Application No: LU/50/21/PL
Site Address: Littlehampton Promenade South of Putting Green Sea Road Littlehampton
Description of works: Provision of 20 No. new beach huts on concrete bearers to broadly match existing.
This site is in CIL Zone 5 (Zero Rated) as other development.

OWPC34839

Floor Plan & Elevations. Scale 1:50@ A3
Arun District Council Beach Hut Application

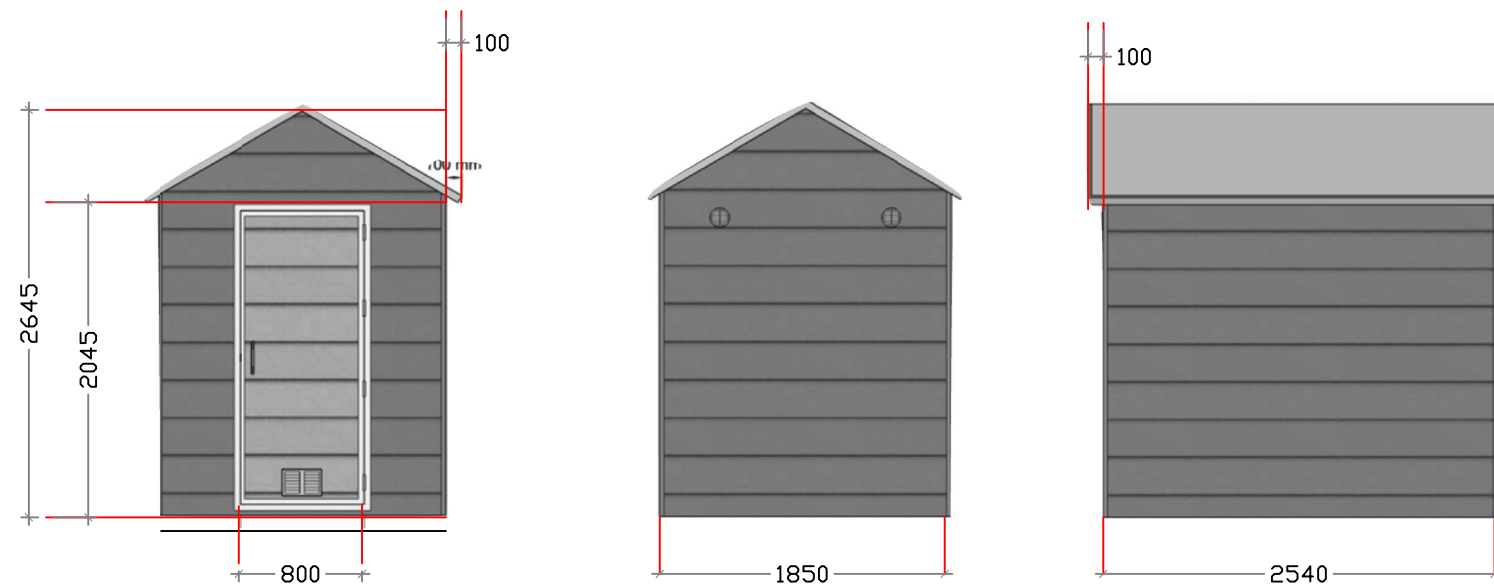
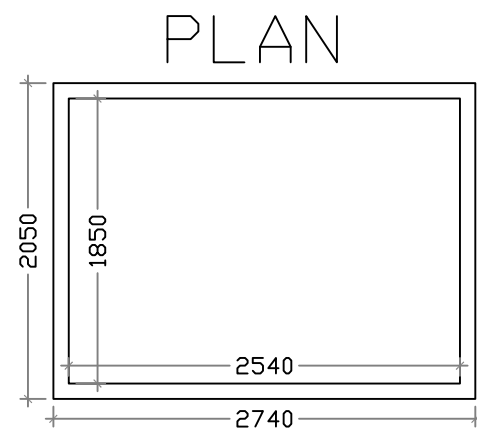
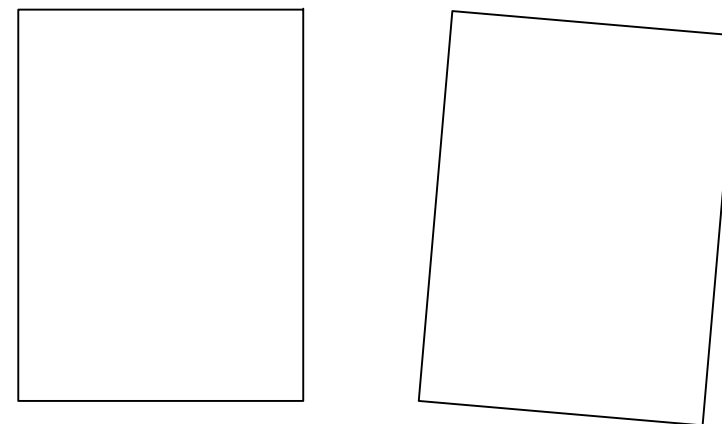
The Town Council's Planning and Transportation Committee considered this matter at its meeting held on Monday 29th March 2021 and had no objection to the principle of the additional beach huts but Members wished to ensure that provision was made to facilitate wheel chair access. The Committee therefore request that the Local Planning Authority consider equipping a minimum of three huts with accessible facilities.
